Application No: K/2/22/HH
Site Address: 43 Golden Avenue East Preston BN16 1QX
Description of works: 2 storey front and rear extensions and alterations.

OWQC44624

Council has no objection providing the case officer is satisfied that:

Proposed Rear (East) Elevation

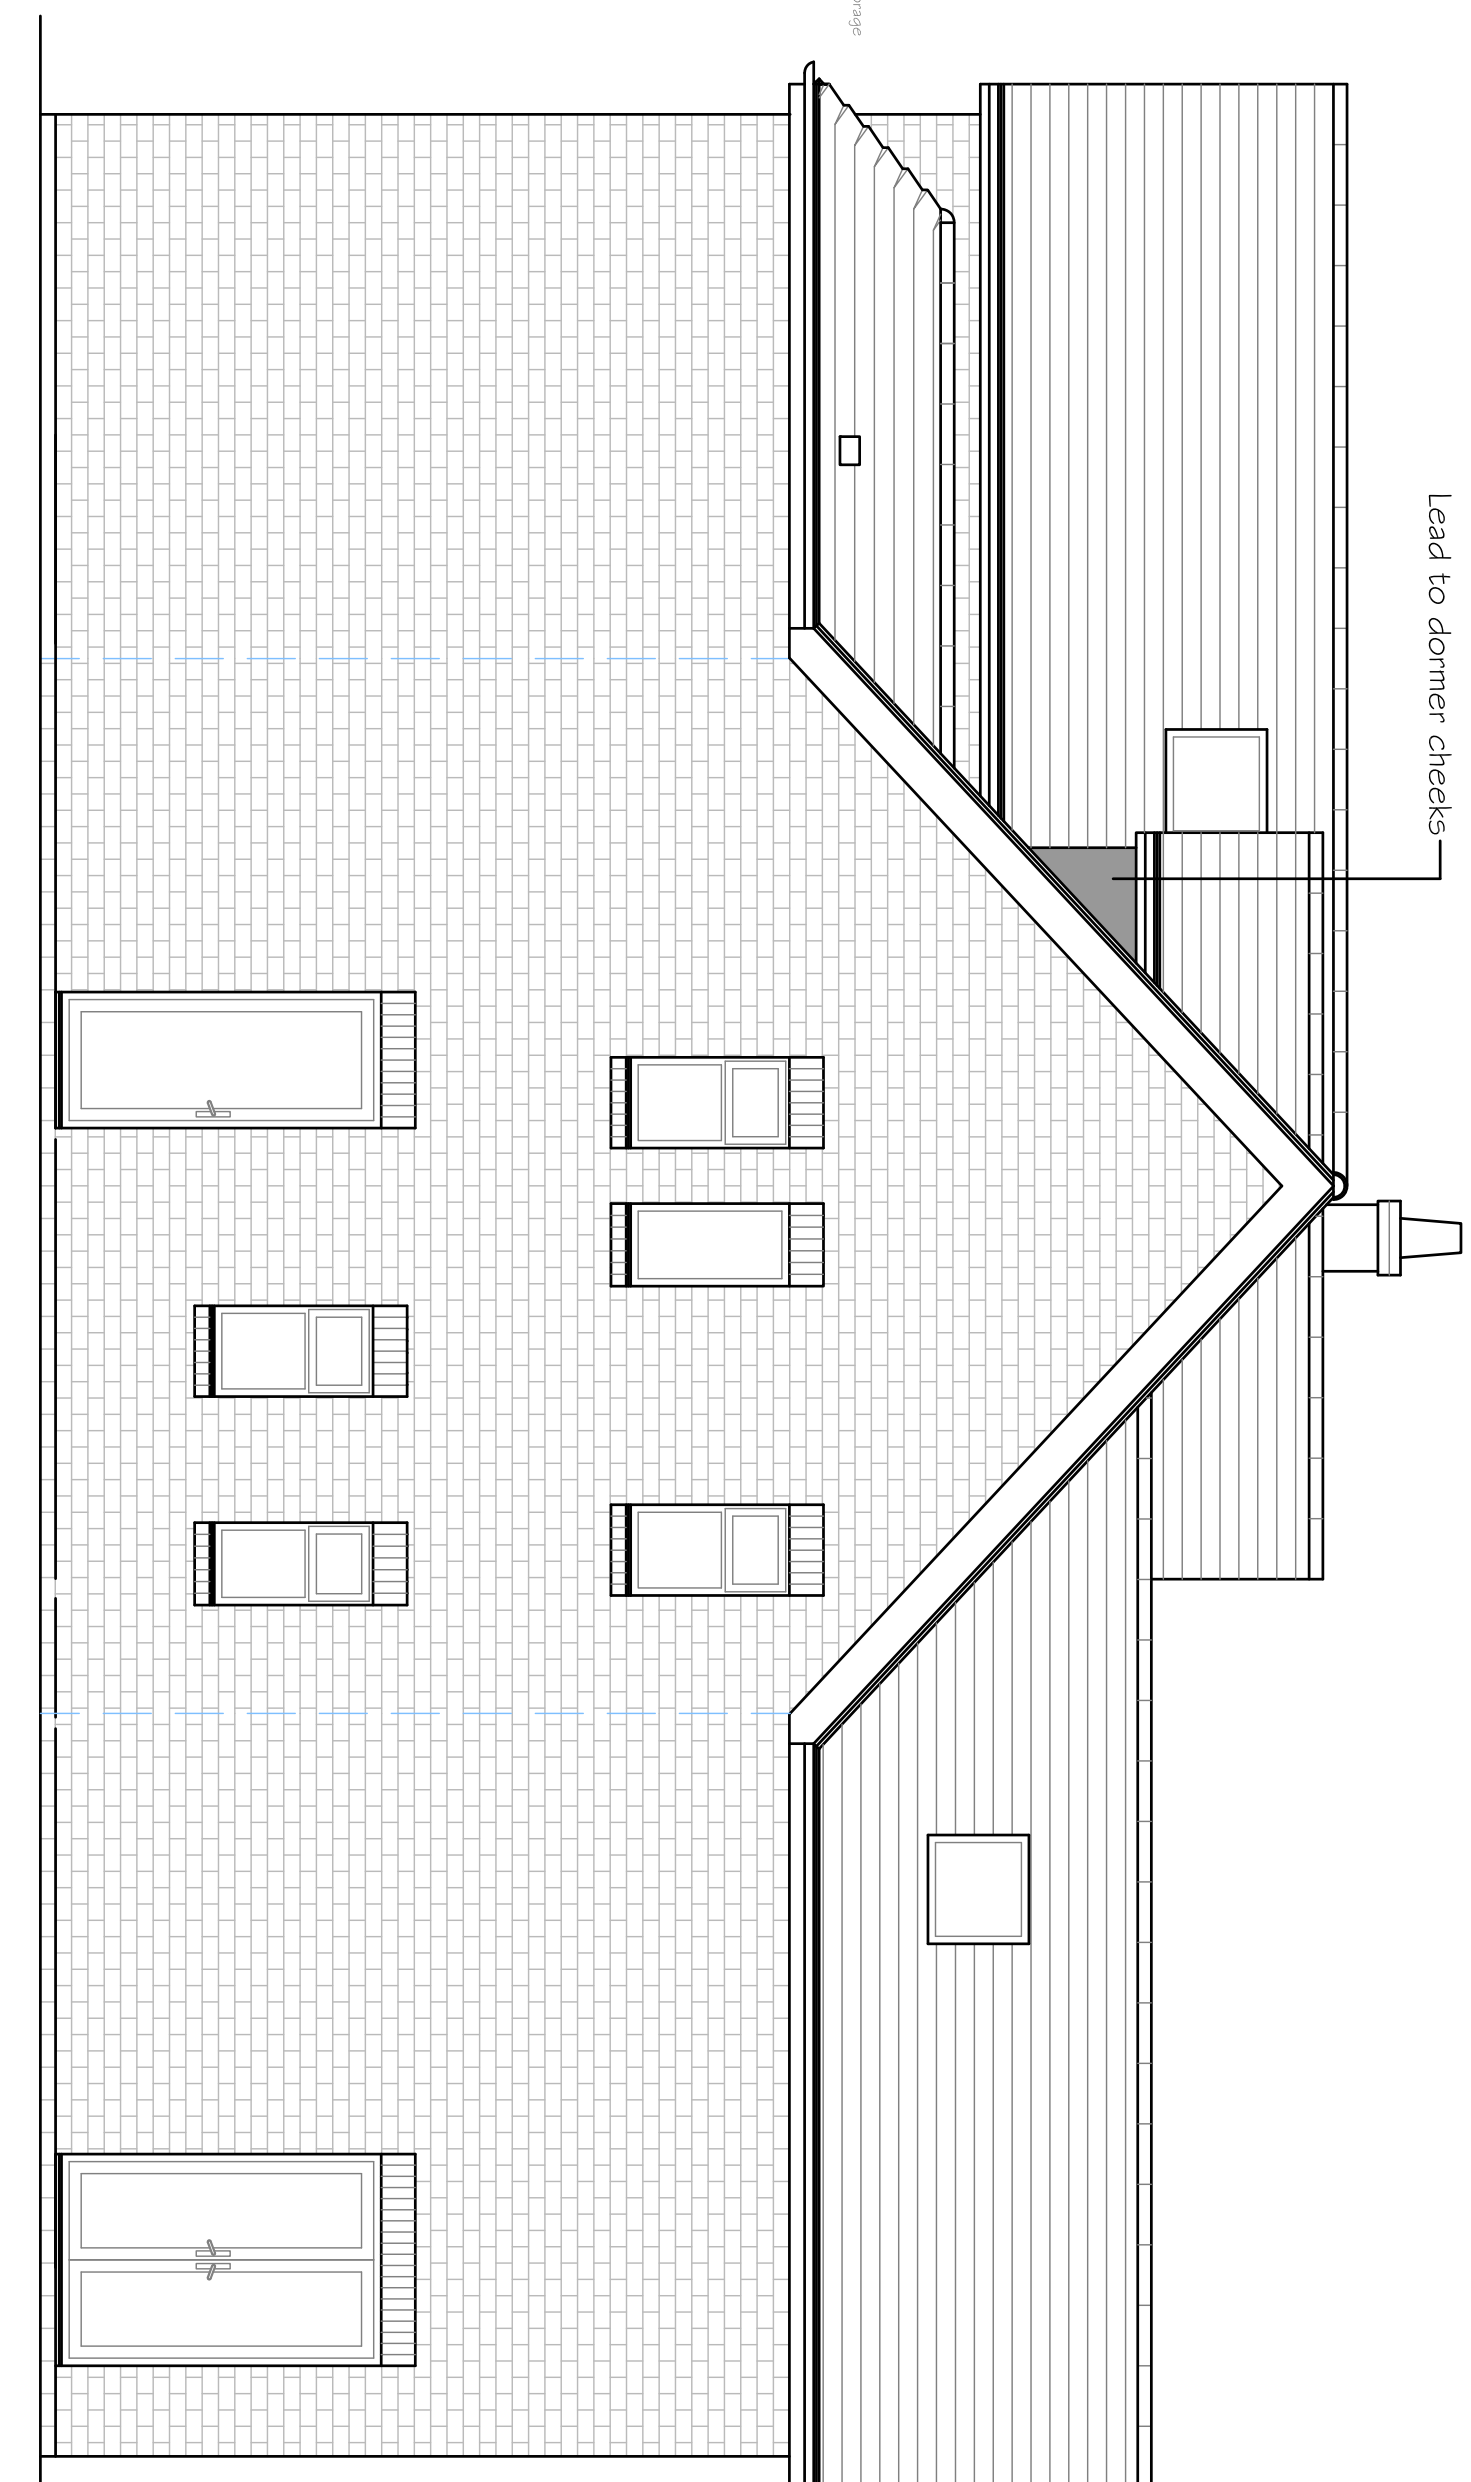
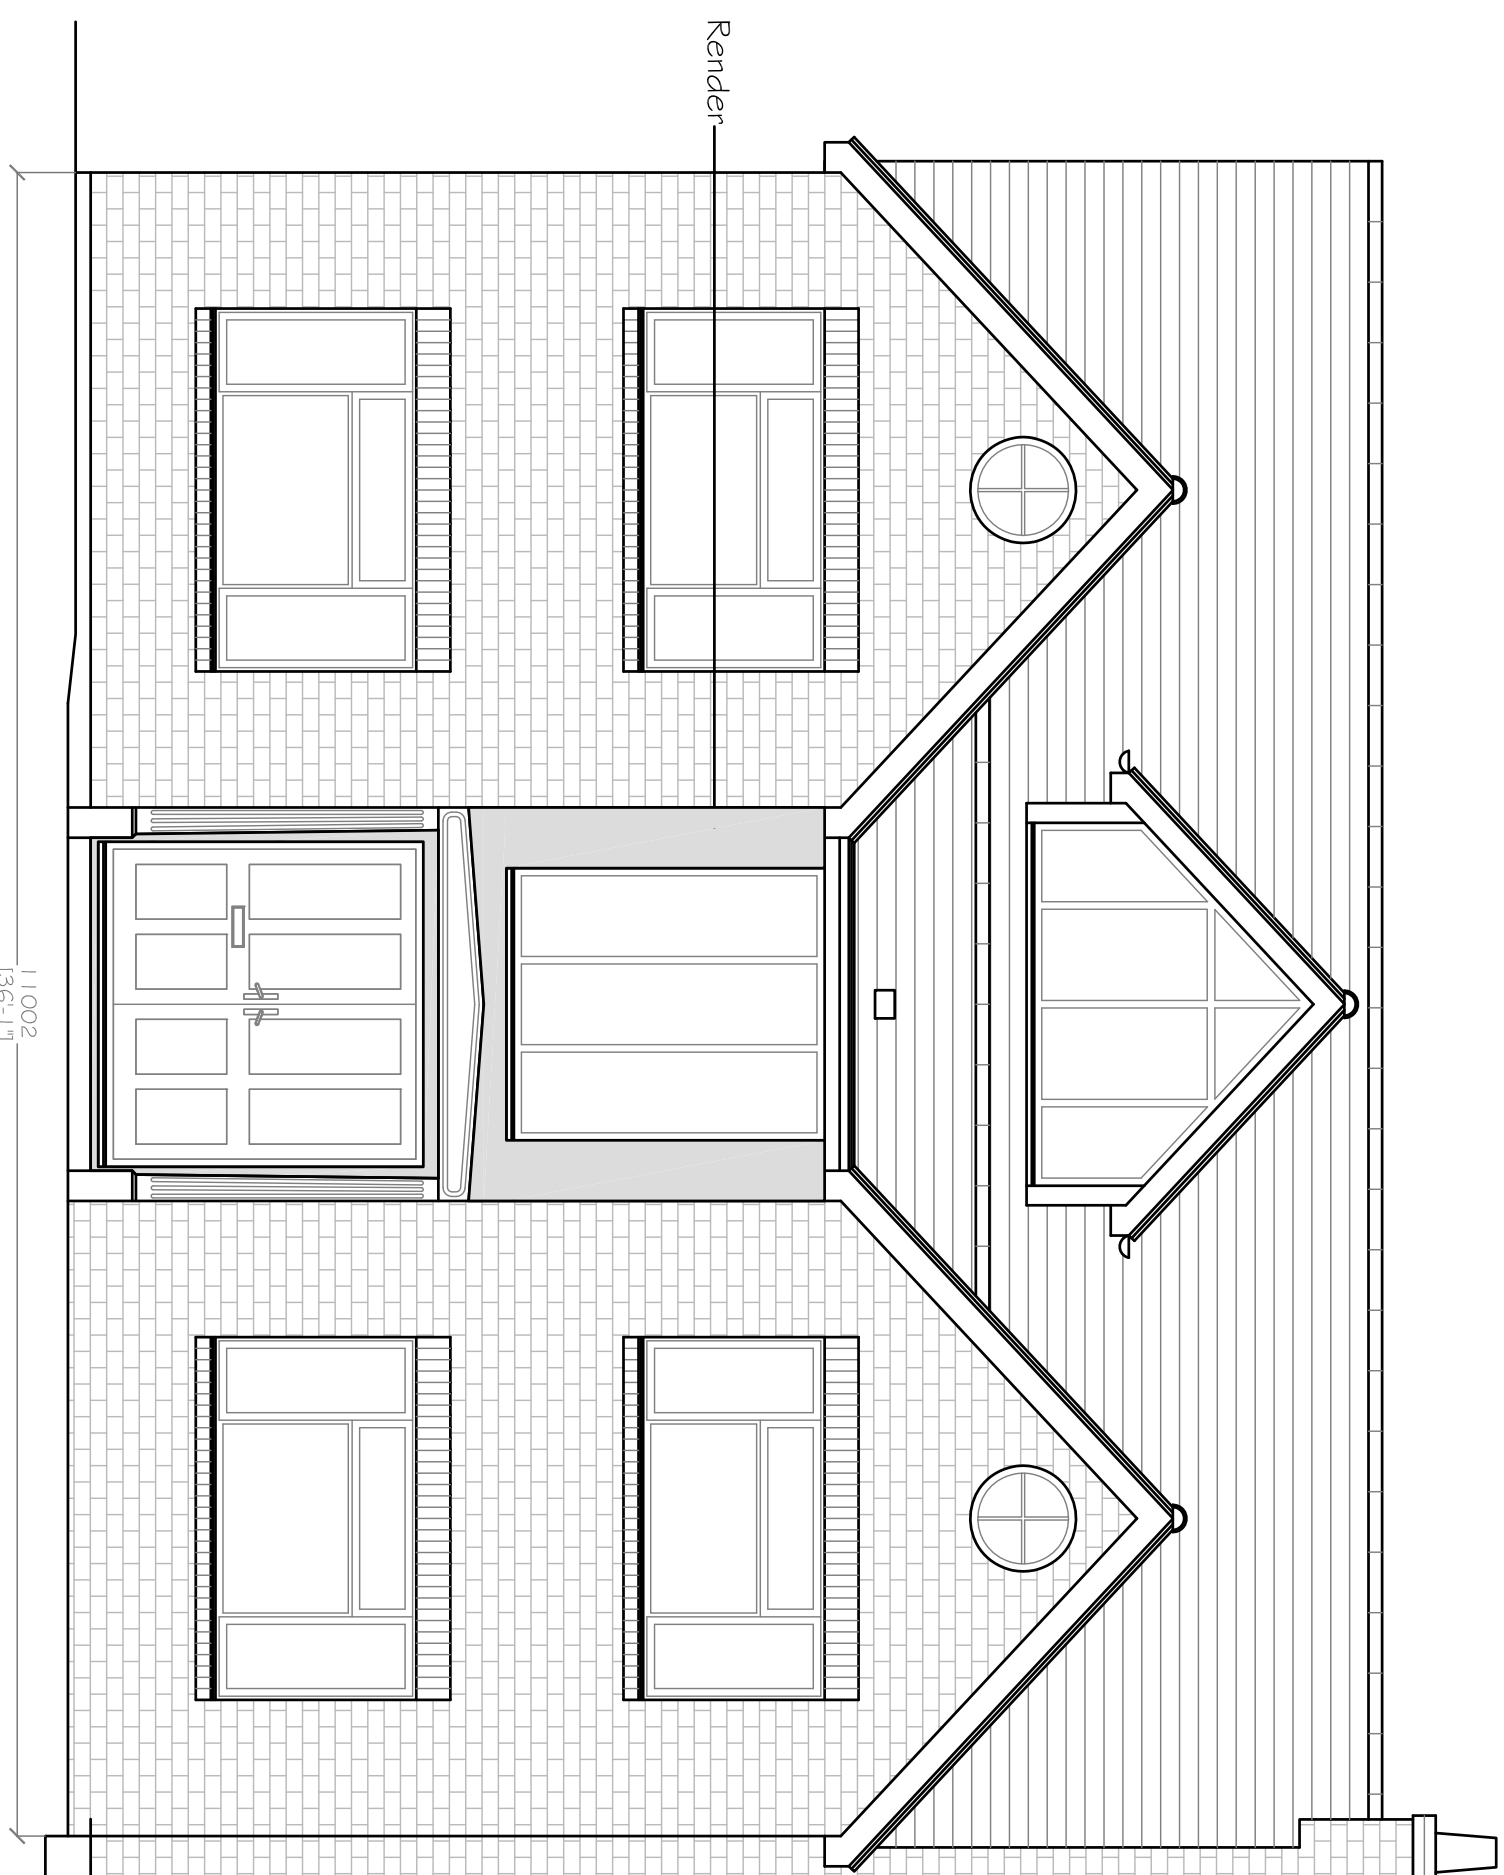
- there is appropriate on site parking for a 6 bedroom property
- windows on the side elevations have appropriate conditions as required to protect the privacy of neighbouring properties
- the new dormer windows and the new balcony at the rear on the second floor have appropriate conditions if required, to protect the privacy of neighbouring properties
